TAMWORTH REGIONAL COUNCIL SUBMISSION – STATE SIGNIFICANT DEVELOPMENT – HILLS OF GOLD WIND FARM – APPROXIMATELY 5 KM SOUTH OF HANGING ROCK AND 8 KM SOUTH-EAST OF NUNDLE

Ref: Ir/SL/GV Document Set ID 606951

10 February 2021

HILLS OF GOLD WINDFARM
TRANSPORTATION ROUTE UPGRADE
INTERSECTION OF WYBONG ROAD AND KAYUGA ROAD
GENERAL ARRANGEMENT PLAN

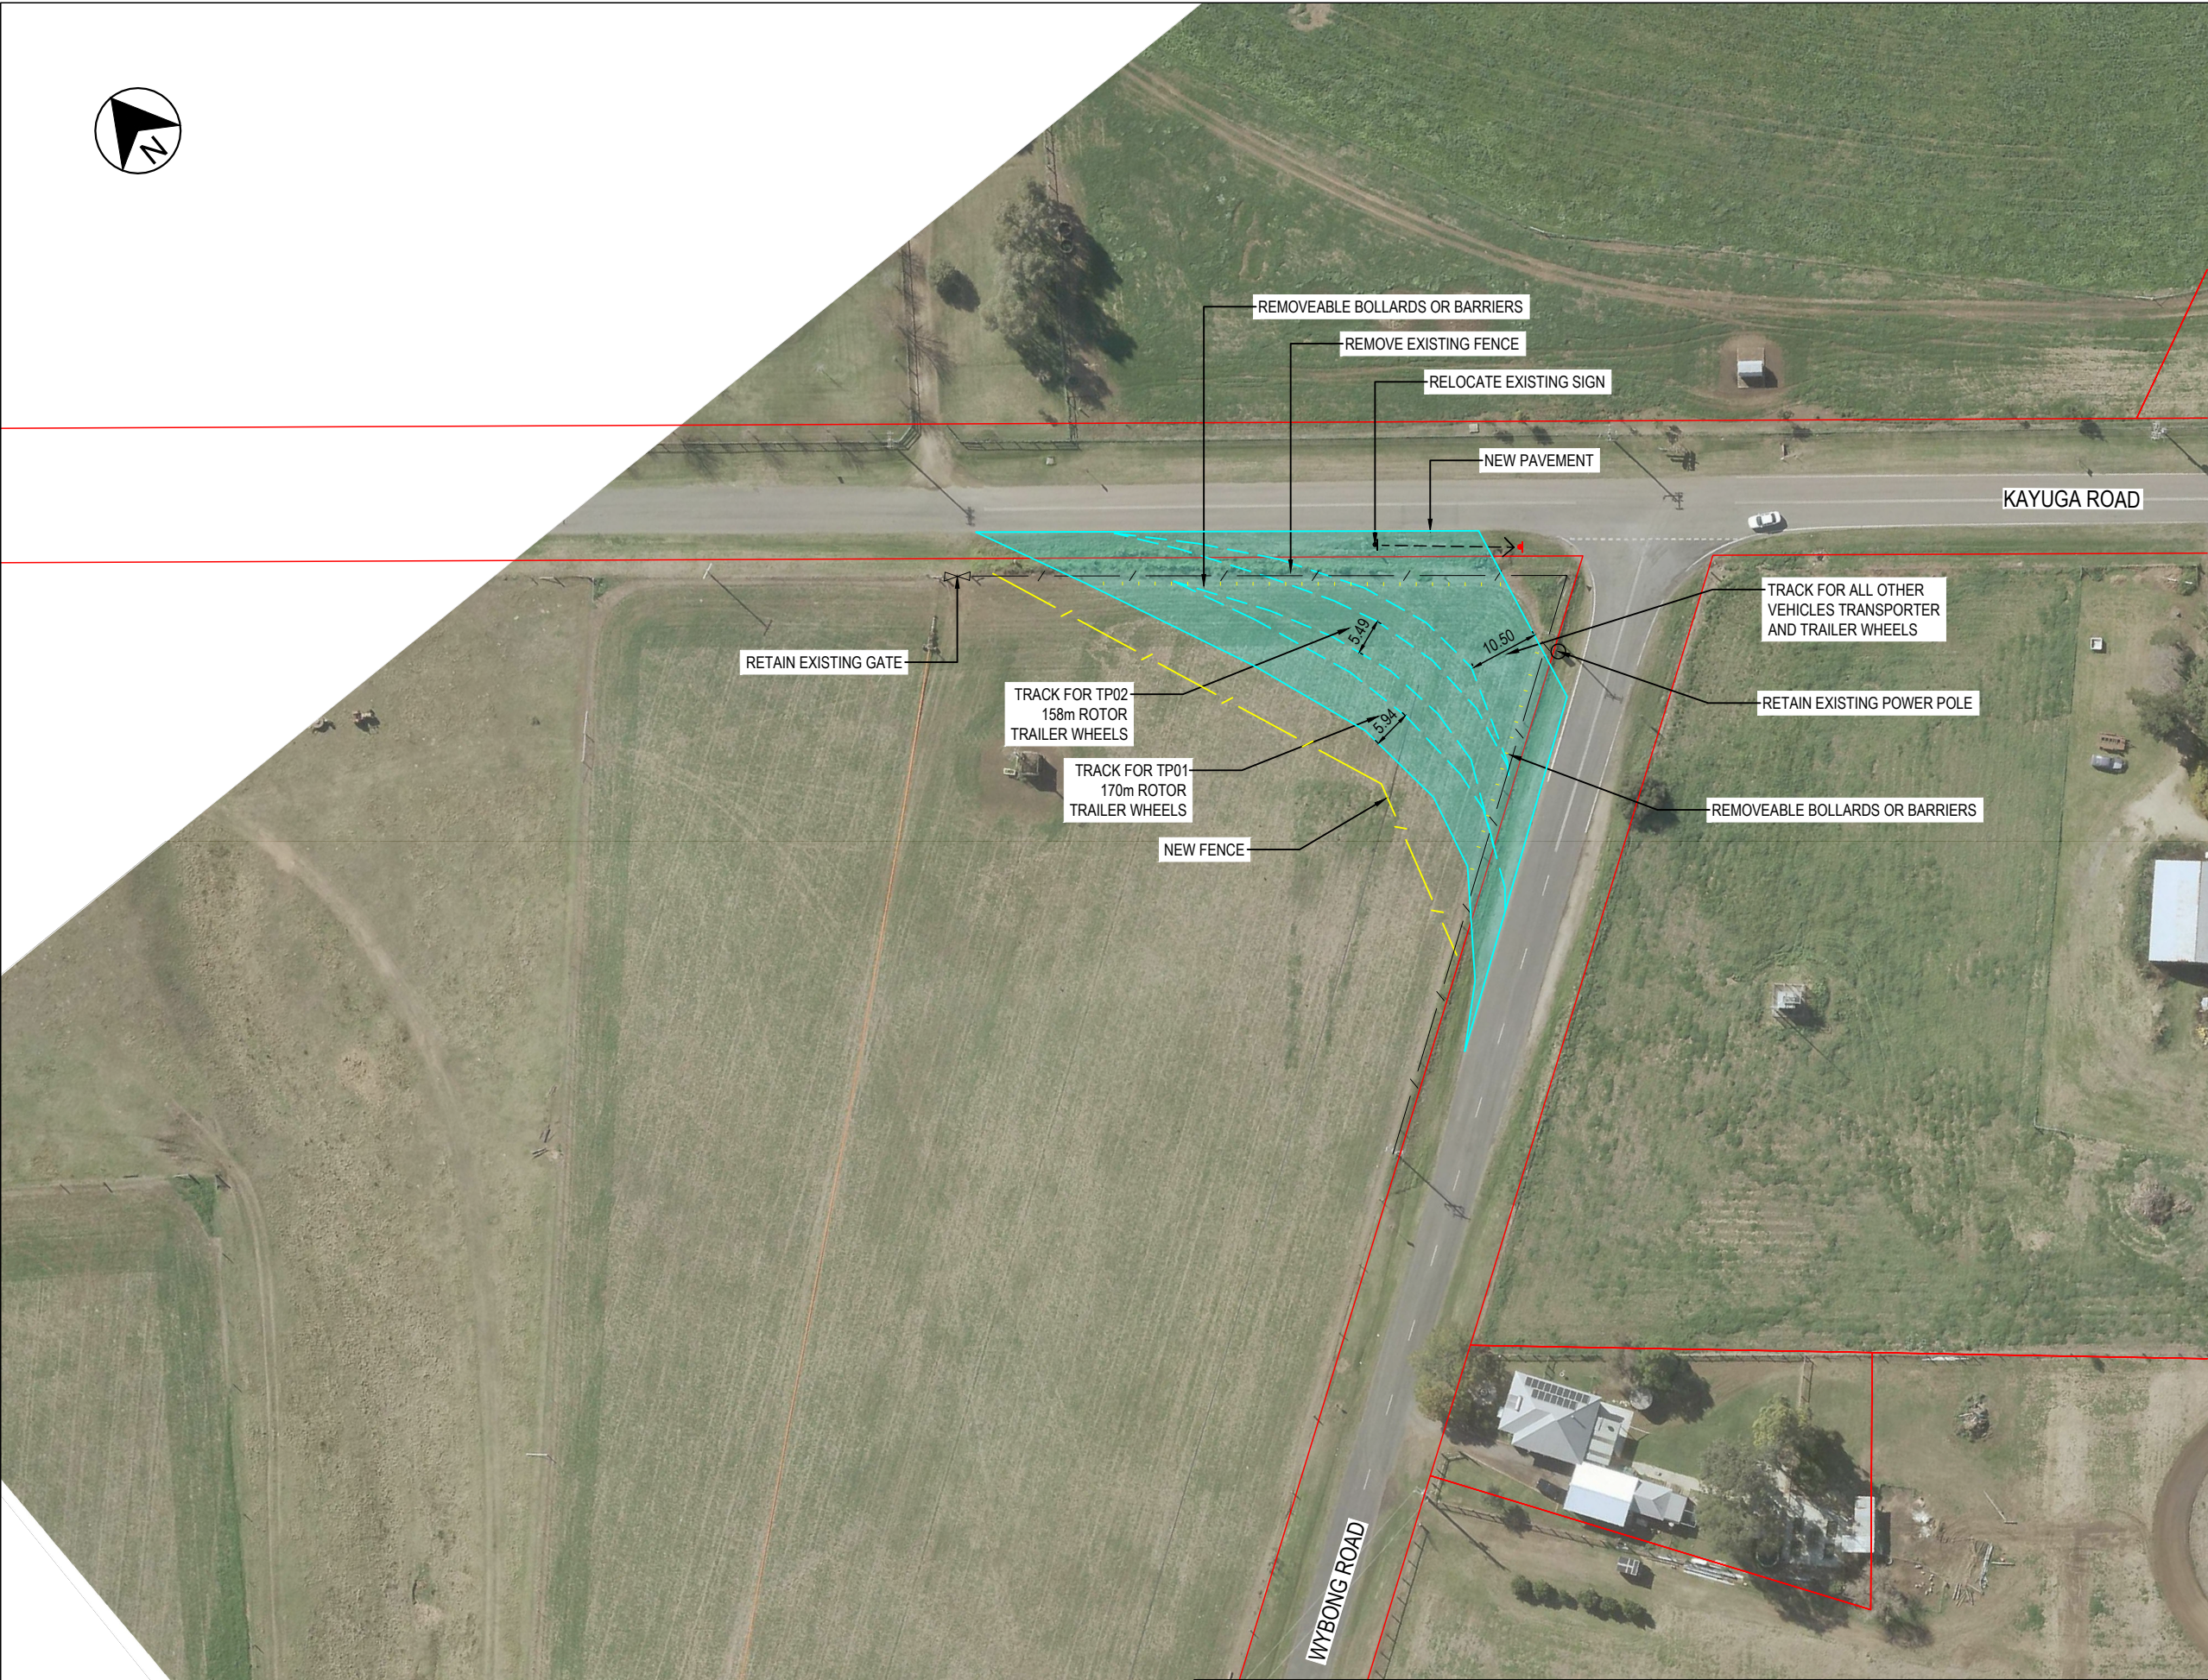
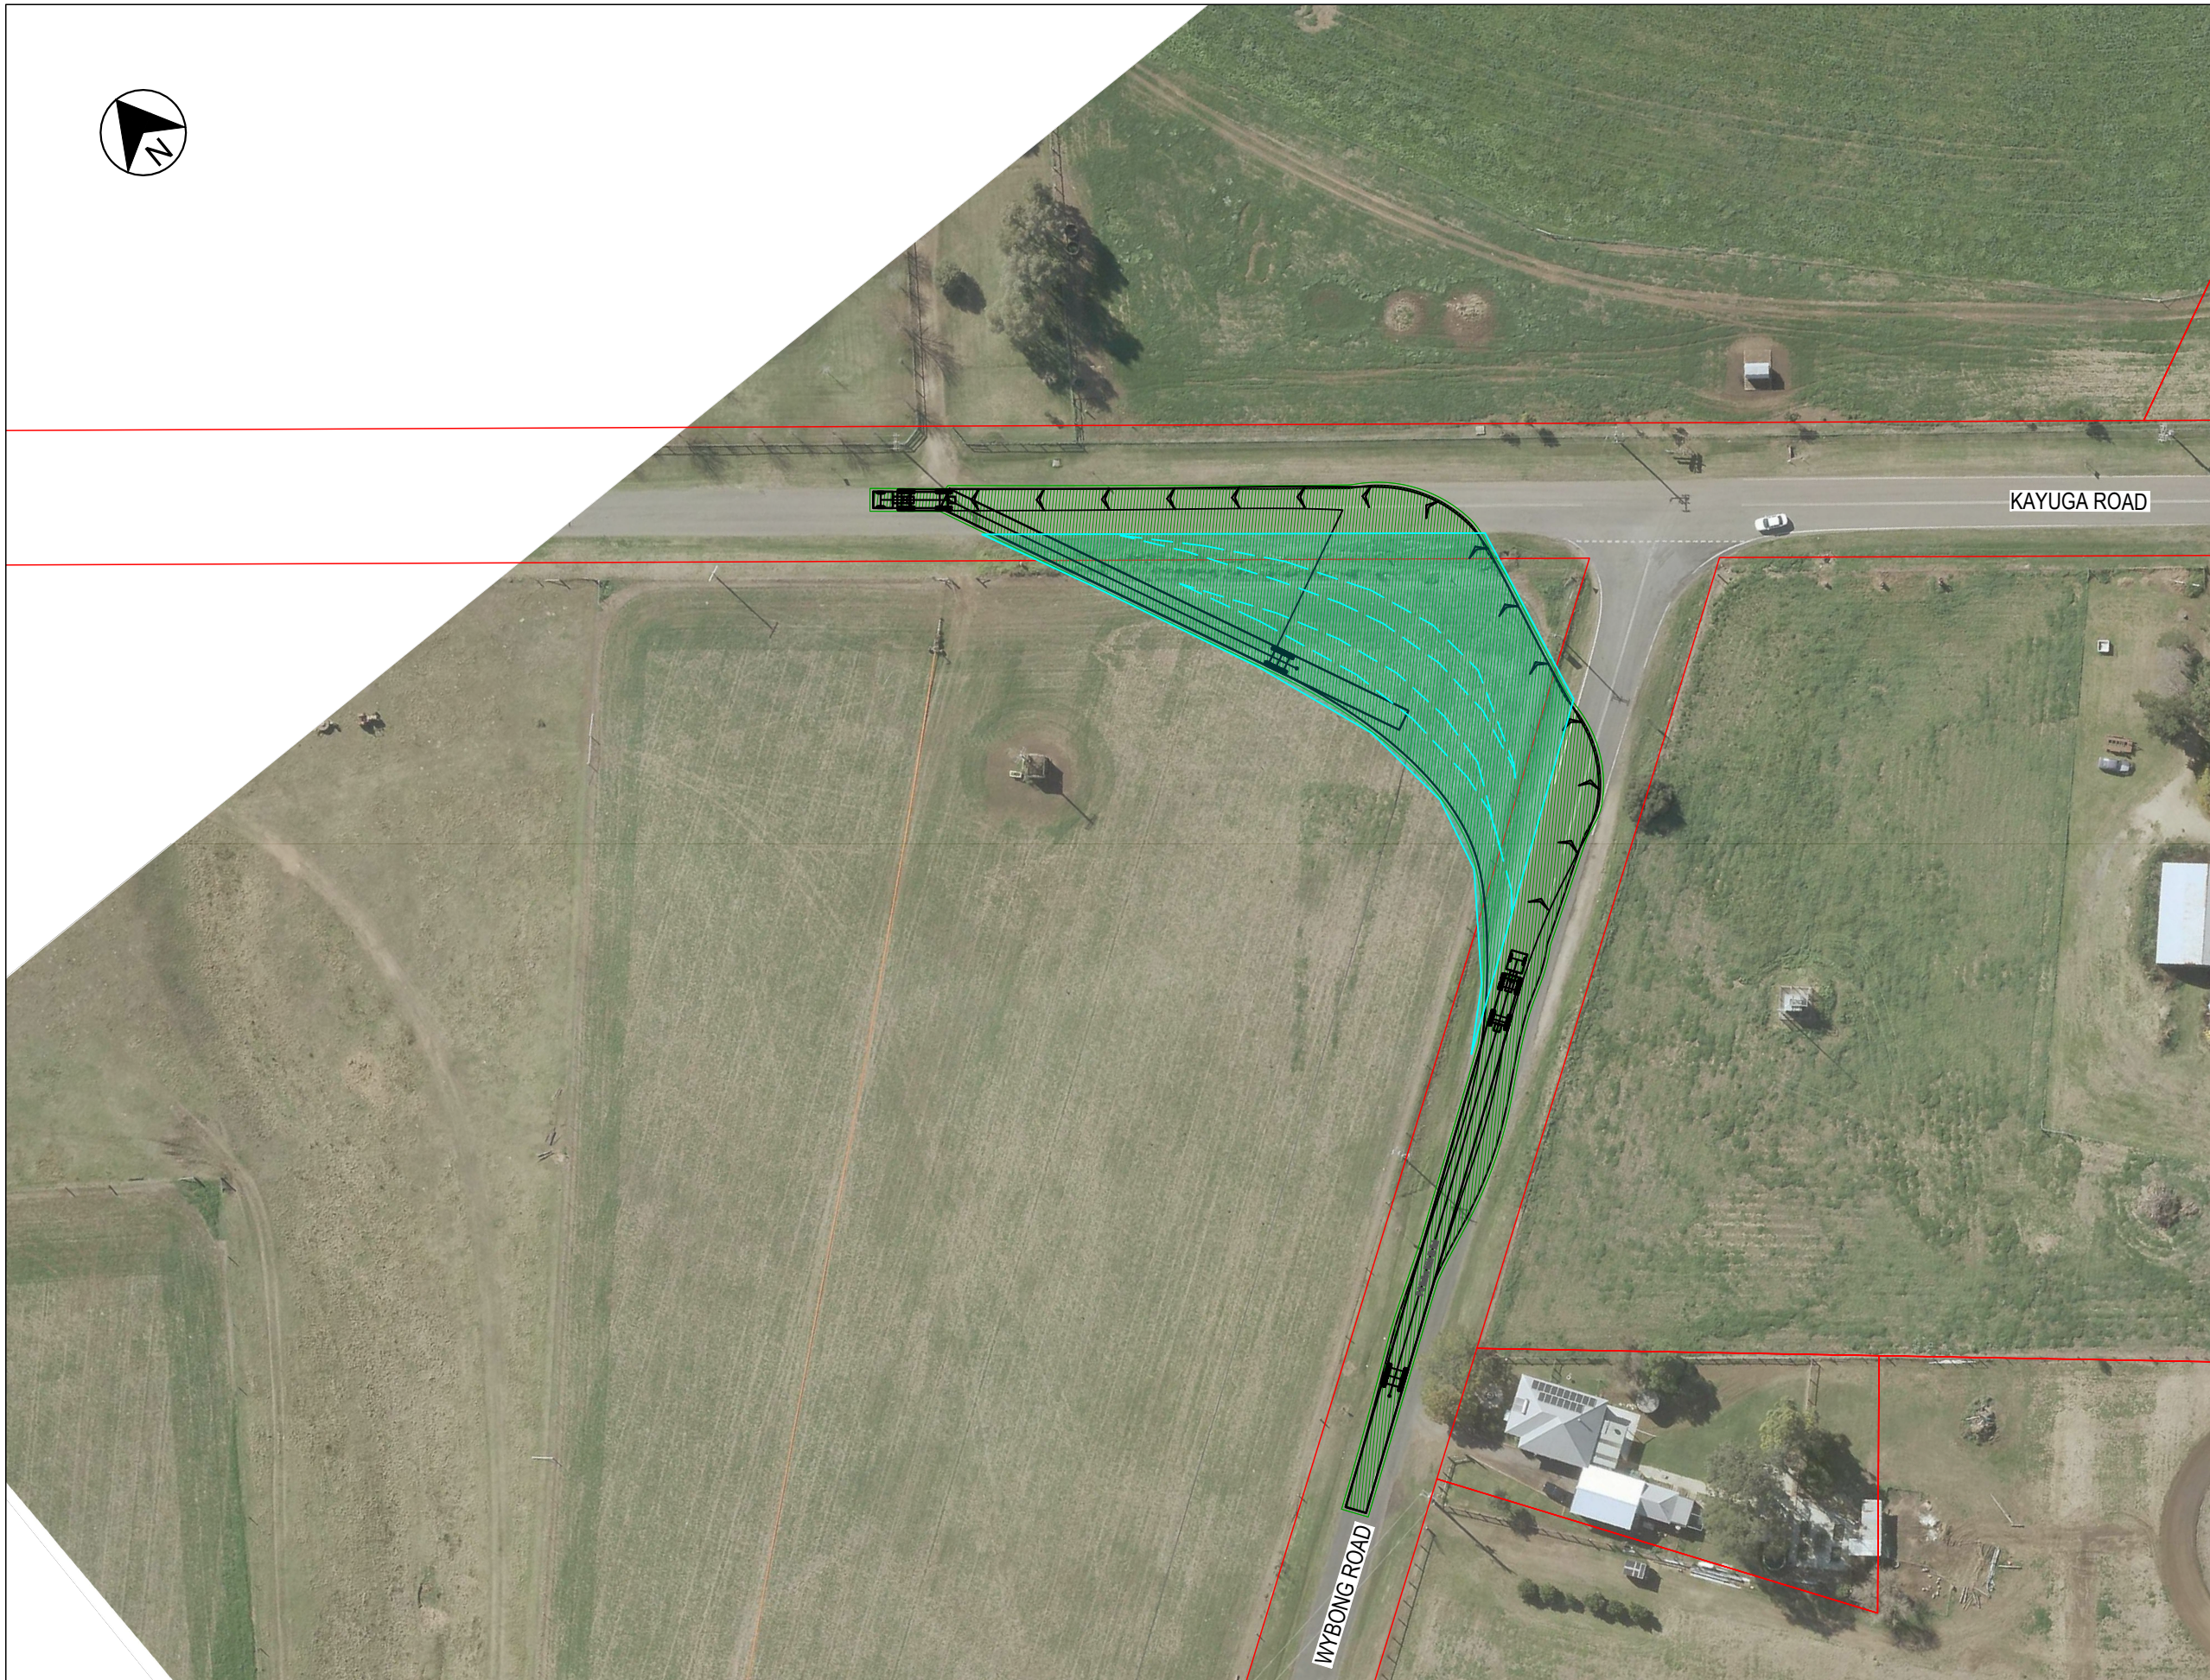
The assessment however appears to be based on *plan-view* geometry and therefore understates the extent of impacted areas where there are *cuttings* and *batters*. The assessment is also confined to identifying the geometric extent of the impact – but does not explore the mechanisms for achieving the extra *clearing*, *infrastructure relocations*, *land acquisitions* and the like.

The intrusions into adjoining landholdings will also need to be resolved with the relevant owners, and an accurate geometric extent will need to be defined in order to facilitate these negotiations.

Whichever route is ultimately selected, road upgrades will be required in order to facilitate the RAV movements. These upgrades will likely include load assessment and resultant augmentation of structures, widening existing narrow bridges and causeways, straightening some of the more extreme horizontal and vertical alignments, and widening certain intersections.
